June 8, 2022

Subject: **Response to Geotechnical Peer Review Comments Regarding
2204-107-SUB1-PLANS**

Proposed Mercer Island Treehouse Residence
5637 East Mercer Way
Mercer Island, Washington

P1.1
 SHORING/PIN PILE DETAILS

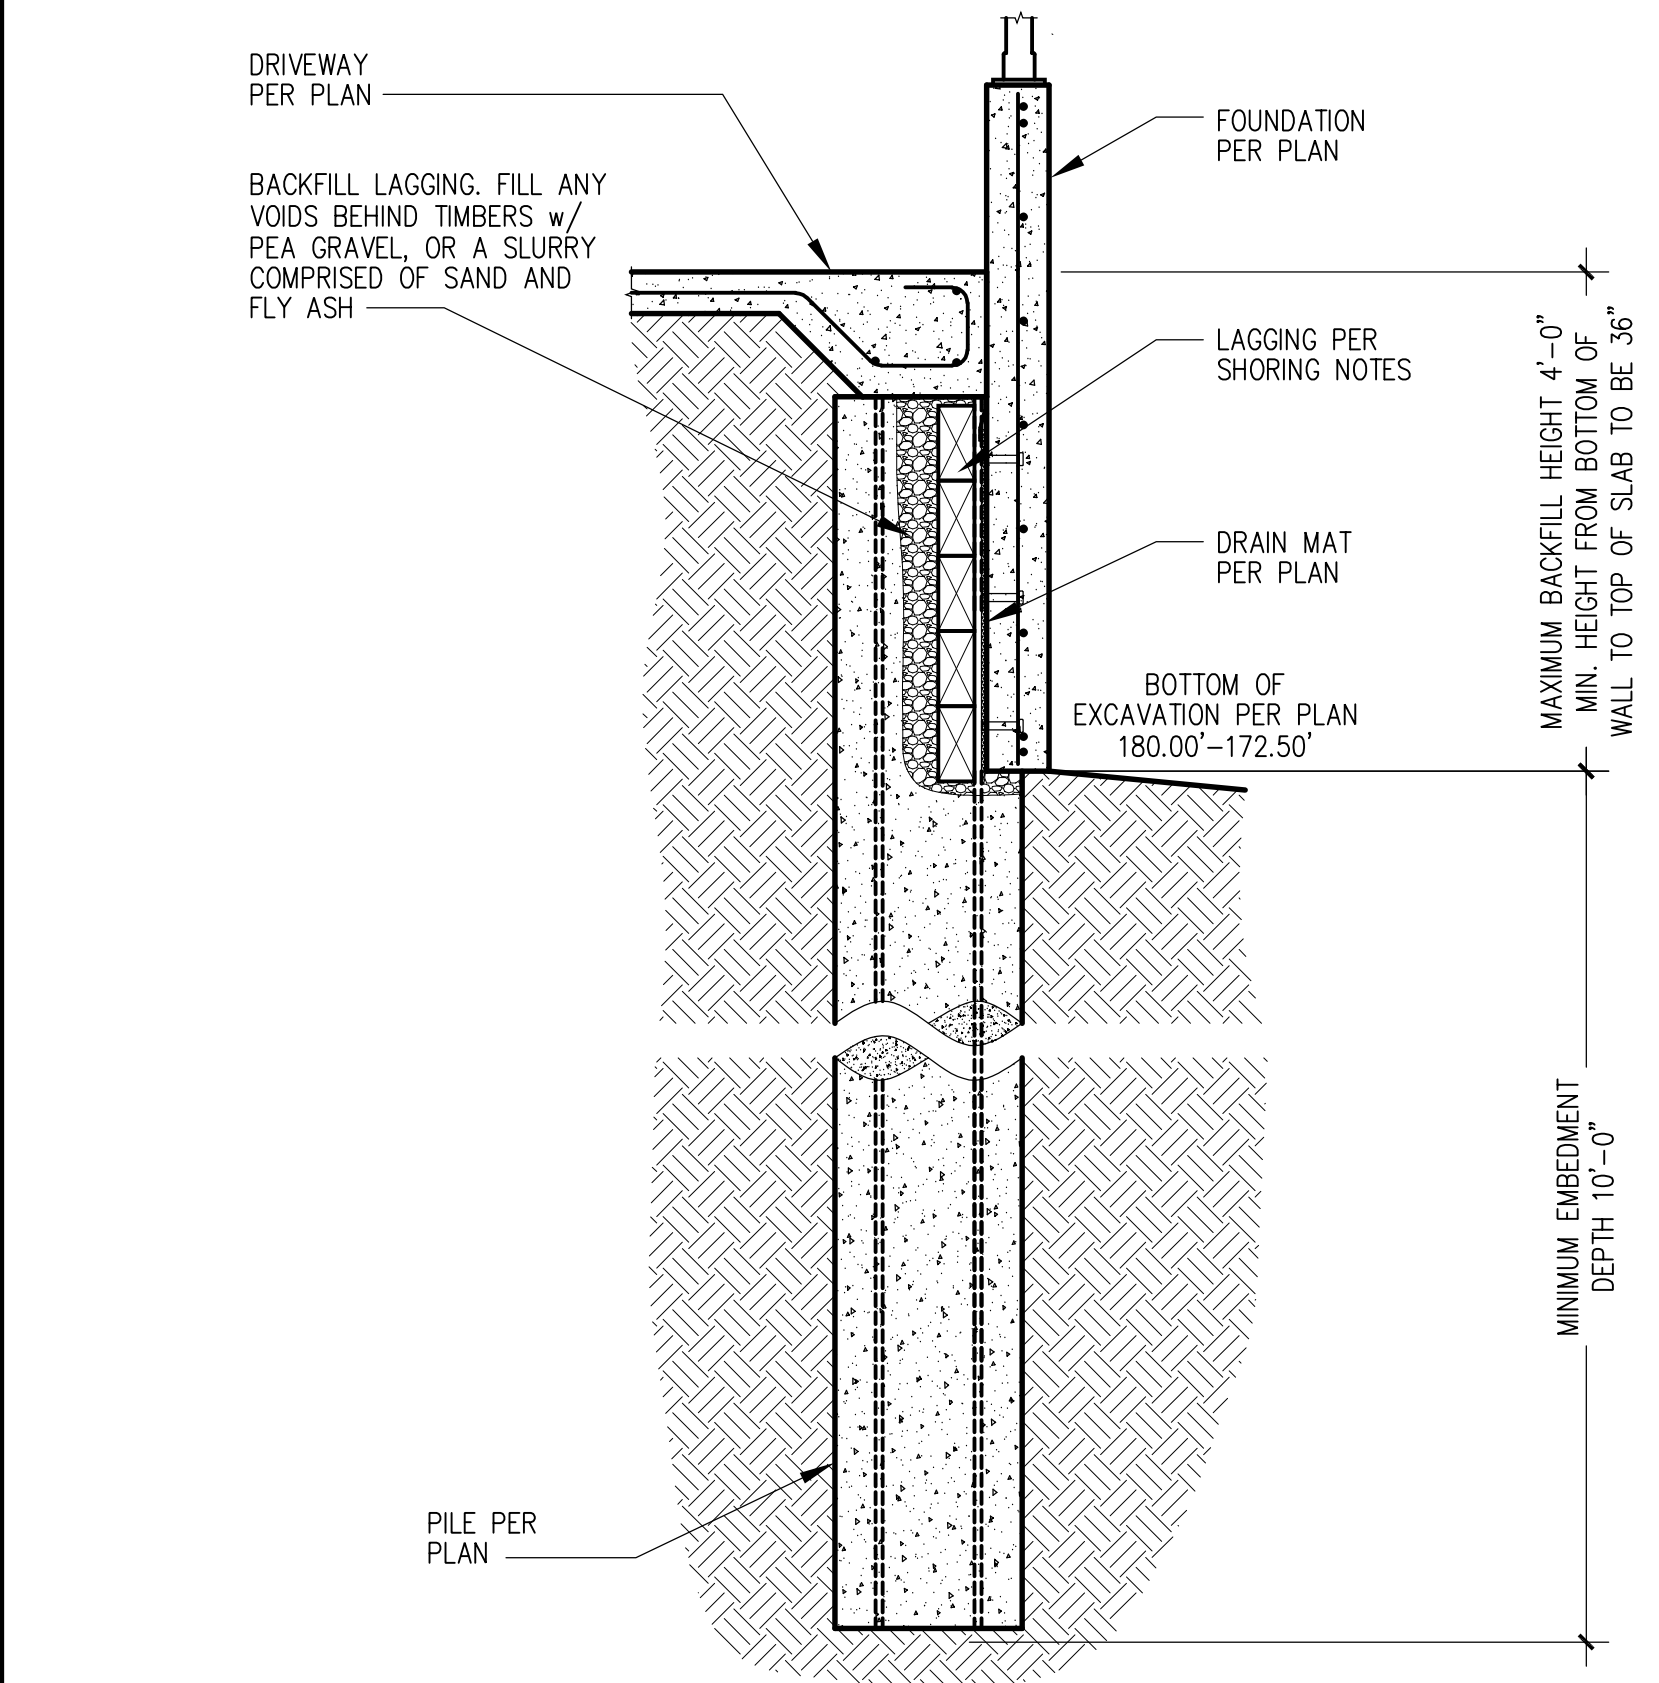
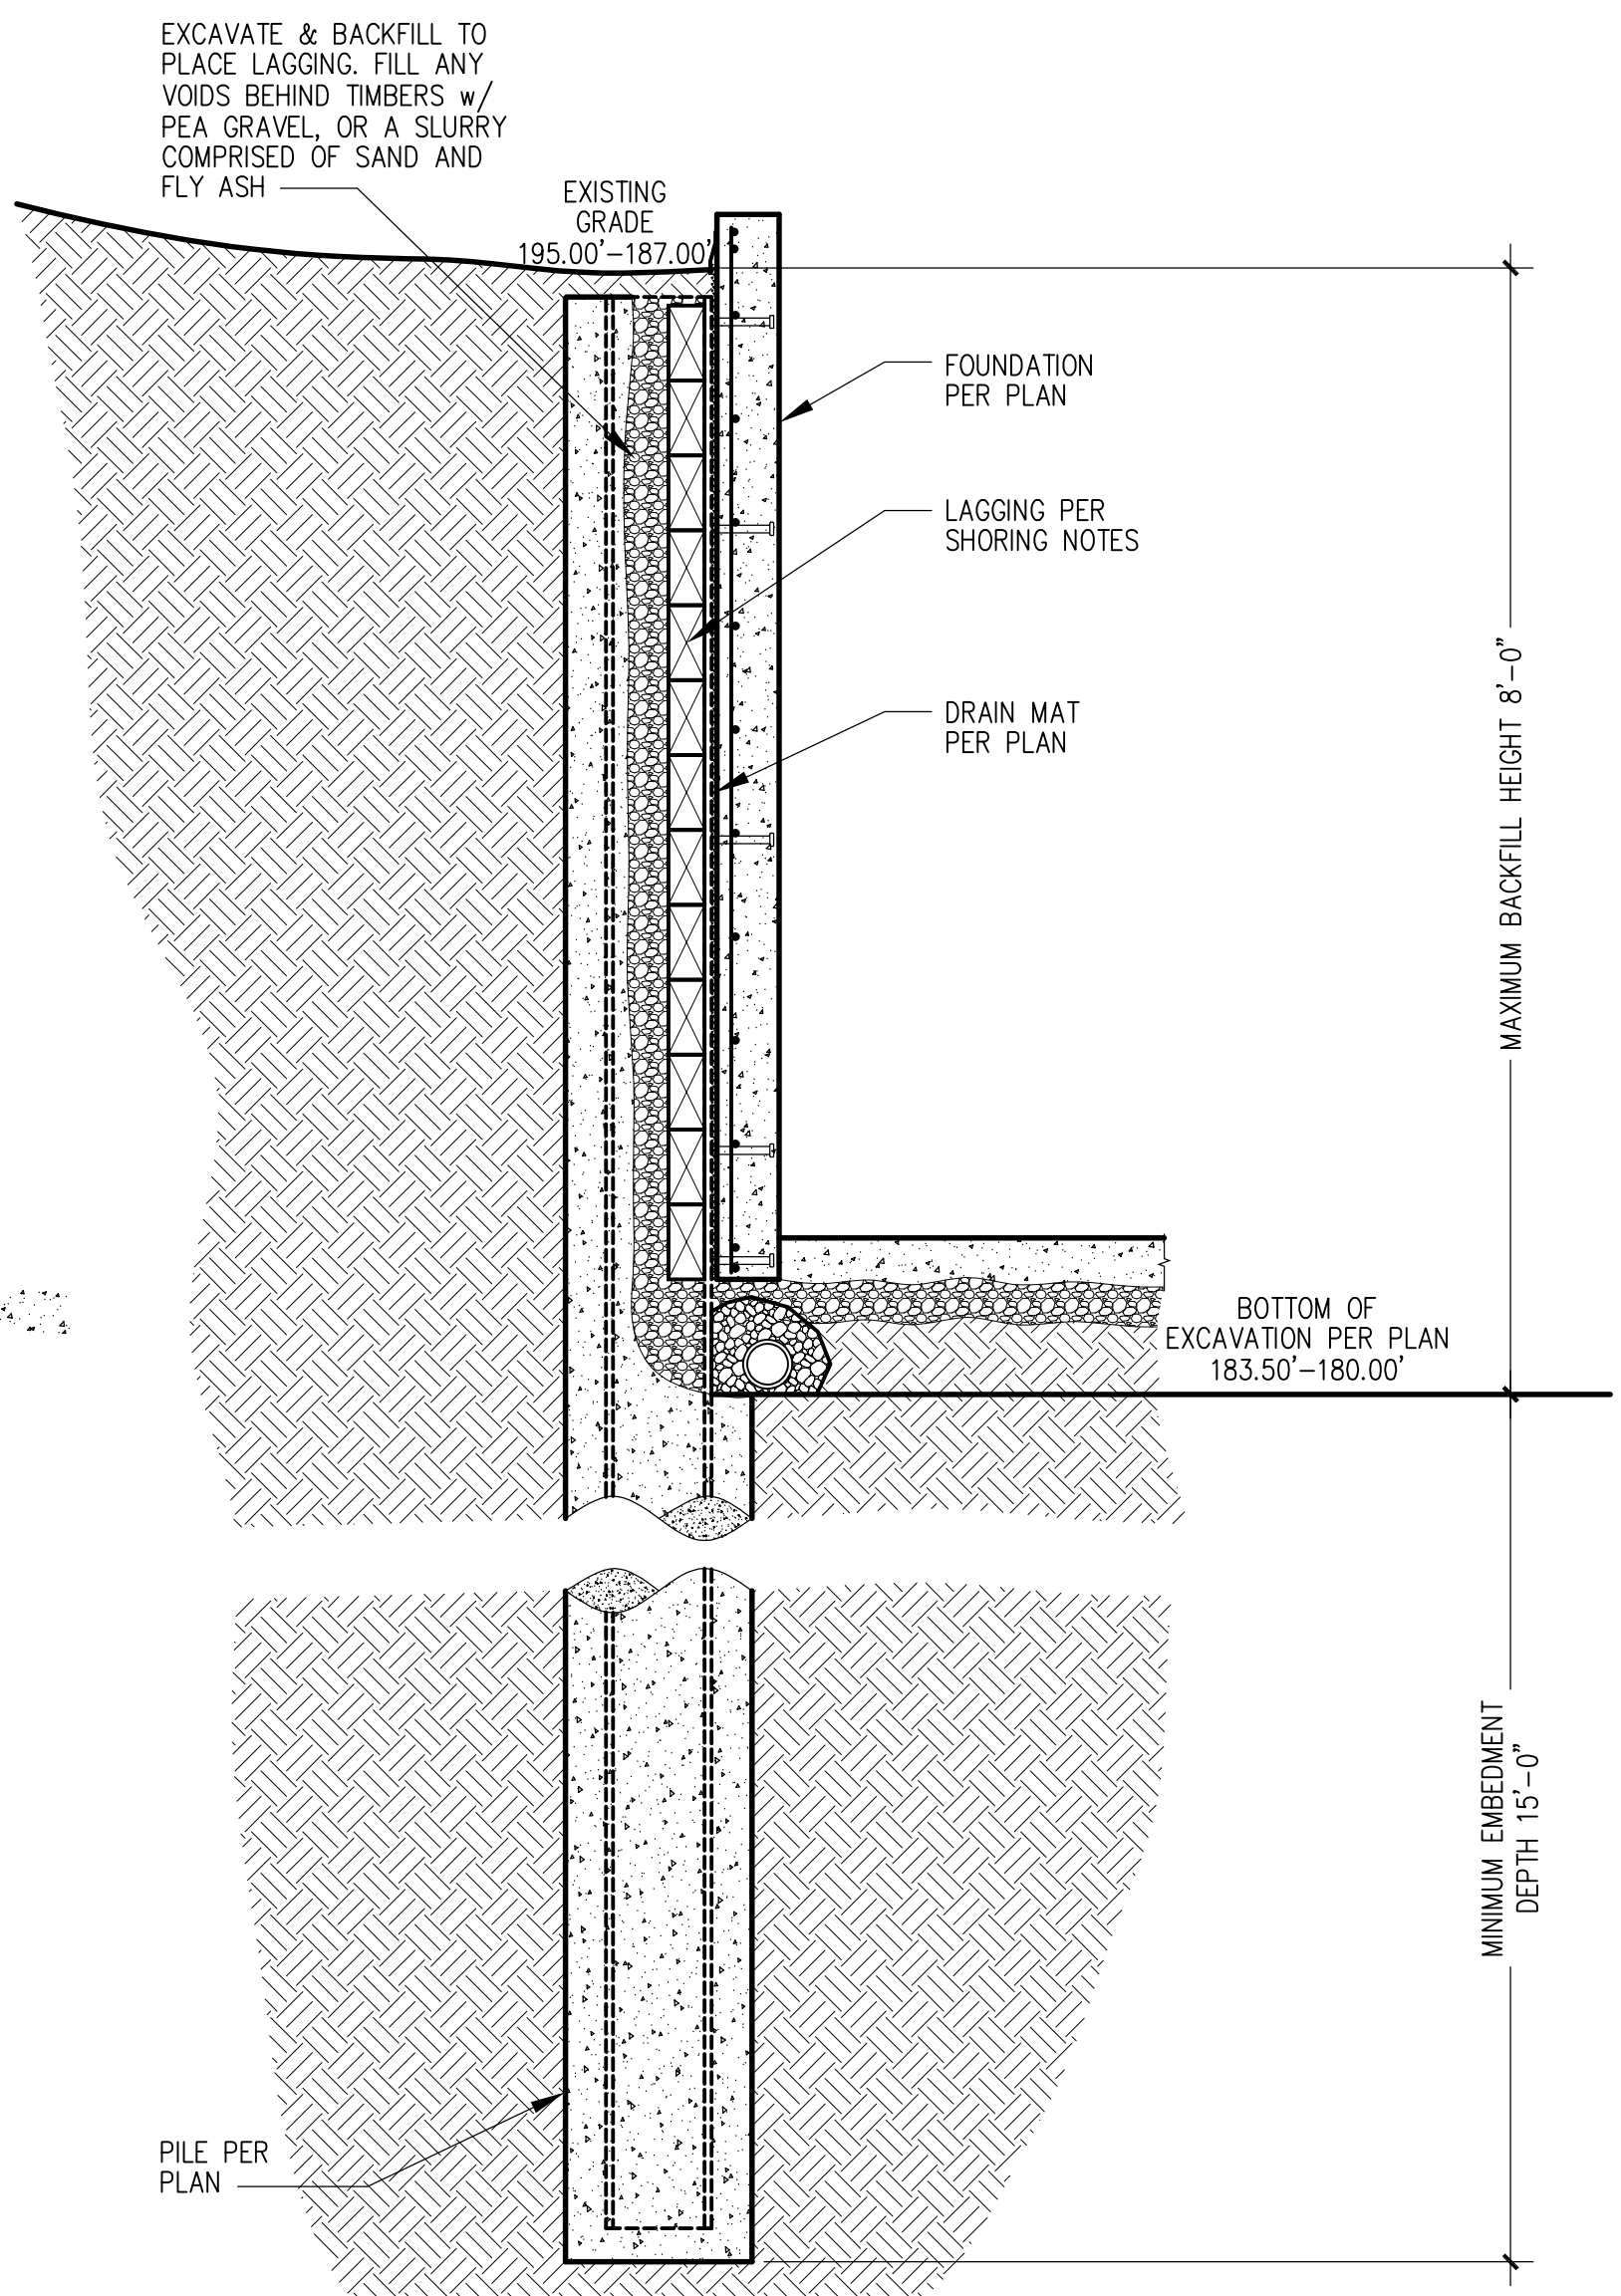
Number: 1 *Isn't this retaining a fill? Wouldn't it be easier to provide drainage and piping behind the wall?*

Provide details on how this wall will be drained or design facing for hydrostatic pressures.

Response: This wall shown on detail 3/P1.1 will be a backfilled soldier pile wall extending along the north side of the driveway. This is also depicted on the North Elevation on sheet A3.4. The driveway area behind the wall will be covered with pavement, preventing infiltration of precipitation into the backfill zone. Groundwater will be below the backfill zone, within the native soils. As a result, the potential for any significant amounts of subsurface water behind the above-grade portion of the wall is low. Drainage of any minimal amounts of water that may accumulate in the backfill could be handled either by a footing drain installed below the existing grade behind the soldier piles, or by installing weep holes through the base of the concrete wall facing. Two-inch-diameter weep holes on 6-foot spacing would be appropriate. If the soldier pile wall is constructed without a concrete facing, the treated timber can be backfilled with clean gravel, and any small amounts of subsurface water will simply weep out through the lagging.

PILE PLAN

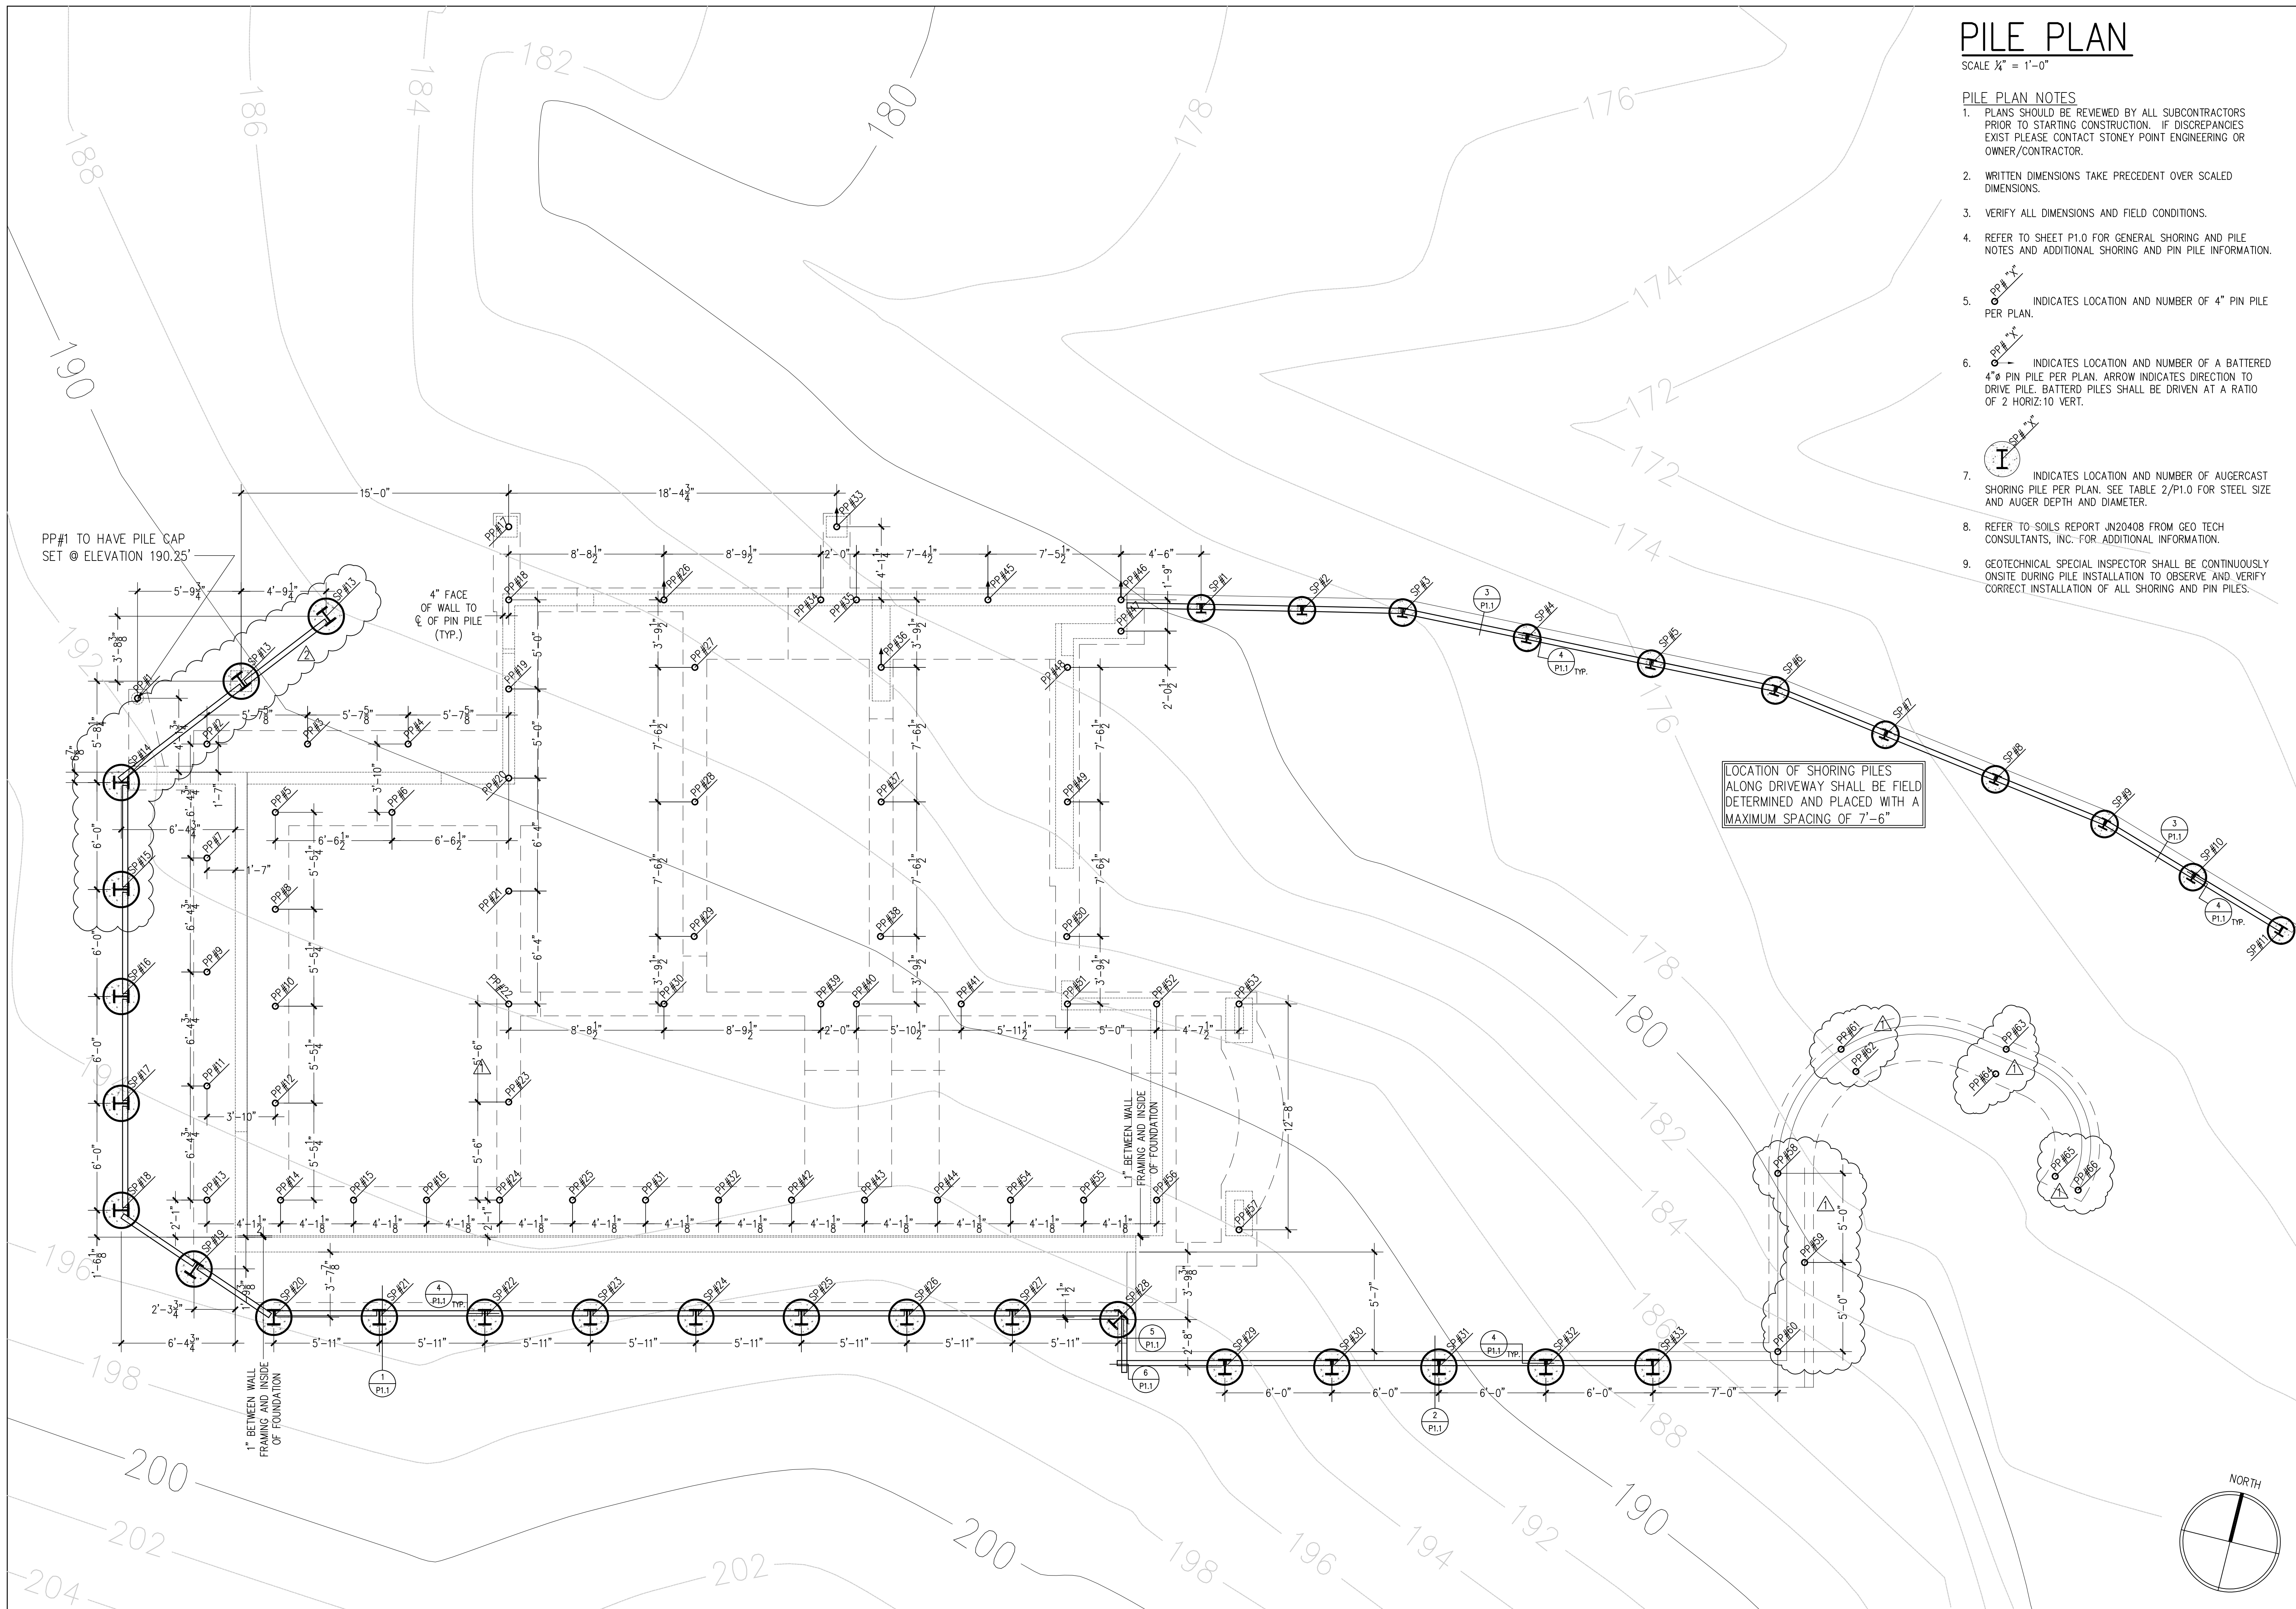
Number: 1 *The wall located adjacent to sloping ground conditions should be designed with reduced passive pressures. Geotechnical engineer to provide recommended values to take into consideration these sloping ground conditions. This value should also take into account saturated soil conditions.*

Revise structural design accordingly.

Number: 2 *Are you backfilling here as shown in Detail 1/P1.1? Are you providing a wall to return? Or permanent slope fill past the end of the shoring wall? Provide final grading if fill slope is proposed.*

Revise plan sheet.

Response: The slope in front of the northern driveway soldier pile retaining wall is located above a short slope only 5 feet in height. Rather than utilizing a reduced passive pressure on the embedded portion of the piles, we recommend that the piles be designed for an active earth pressure acting to 2.5 feet (one-half of slope height) below the existing grade. The passive pressure below this 2.5-foot depth should be an ultimate value (no safety factor included) of 225 pounds per cubic foot (pcf) acting on 2 times the drilled pile diameter. This passive value accounts for the buoyant unit weight of the soil below the water table.

Response: The retaining wall indicated in this comment is actually a landslide catchment wall consisting of soldier piles that extend above the ground surface. The base of the catchment wall will follow the existing grade, and will not retain fill above the existing grade.

There is no need to revise the plan sheet for this item.
